Rezoning Transportation Analysis

Petition Number: 2020-035

General Location Identifier: Tax ID 04711201

Date	Description
03-25-20	First Review
04-23-20	Second Review
06-25-20	Third Review (KP)

SHEET NUMBER  
**RZ-2**

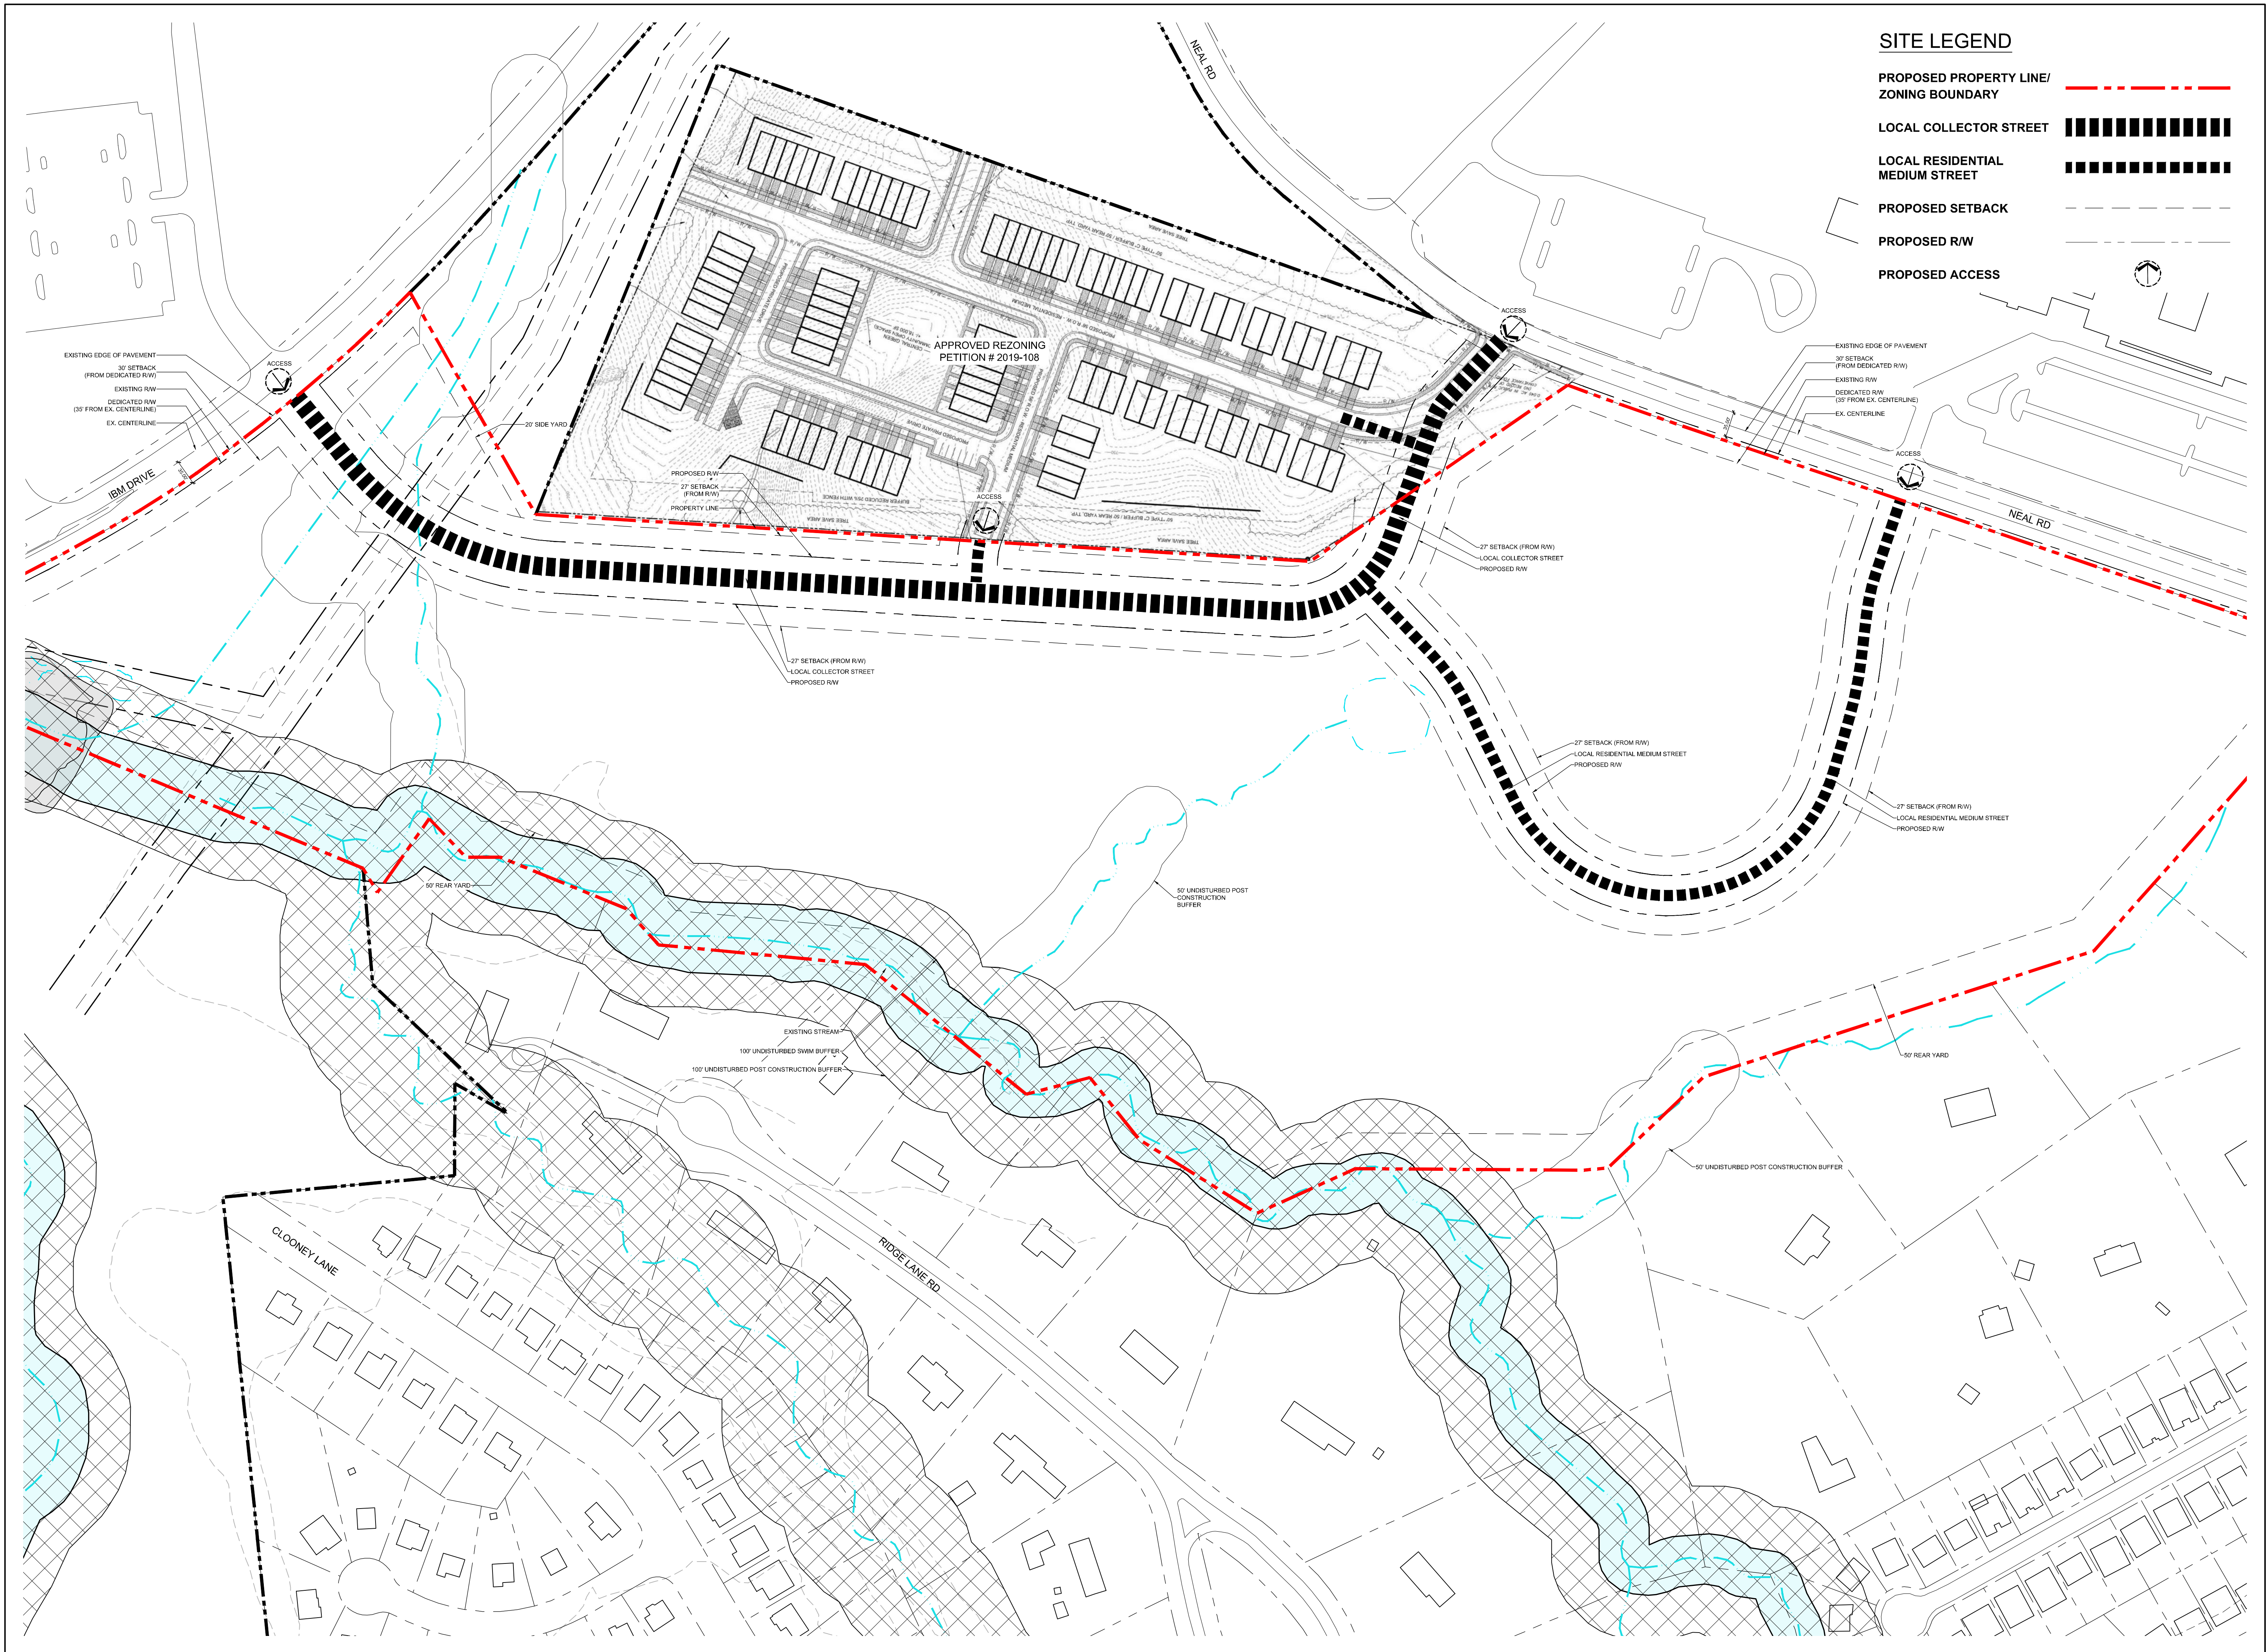
The site plan should show the curb and gutter labeled and dimensioned from the centerline for each road.
2. **Traffic Study** A Traffic Impact Study is typically necessary for a proposed development, if the site generates 2500 daily trips. In this case, the site will be fourth leg of a signalized intersection at IBM Drive, therefore, it triggers a traffic impact study under CDOT Traffic Impact Study Guidelines.

- b. The petitioner needs to provide an existing queuing analysis for the school driveways on Neal Road to fully understand the traffic situation and to adequately locate the driveways.
